Application No: AW/48/21/HH
Site Address: 17 Kingsway Aldwick PO21 4DQ
Description of works: Roof alterations to provide extension to existing first floor and swimming pool in rear garden. This application affects the character and appearance of the Craigweil House, Aldwick Conservation area.

Thank you for your internet representation made on 17th March 2021 which has been recorded as an objection with the comments as follows:

block plan
1 : 500

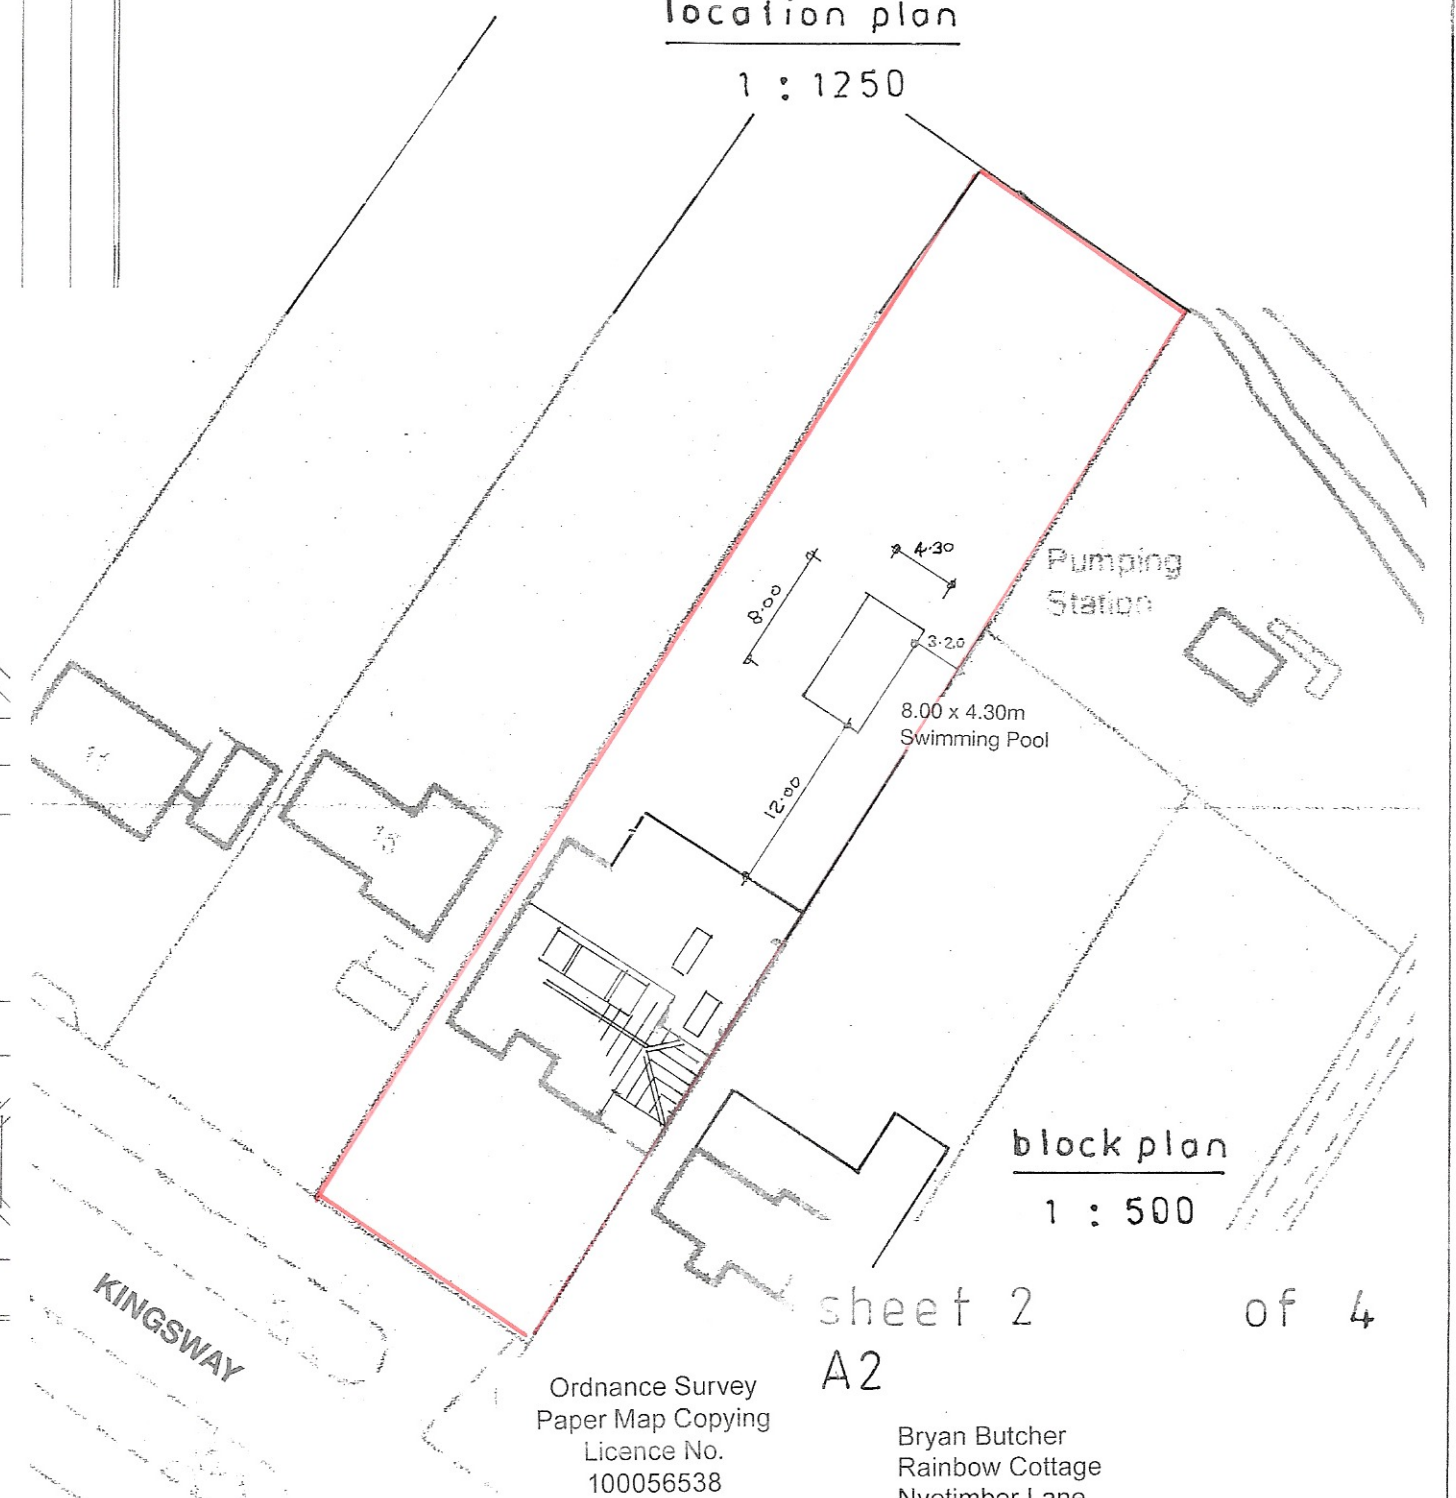
the above planning application also shows the siting of a swimming pool but no further details. at some time there had been a fountain at the bottom of the garden of no 17 as a derelict tank and pipe were discarded in that part adjoining the culvert.

Craigweil is a quiet estate with no background noise such as the hum of constant traffic and the introduction of pumps, filters, cleaning systems and whatever else is needed will affect not only the long narrow gardens on either side but the local area. the drainage will also be affected, at a time when it has to cope with more than usual rainfall
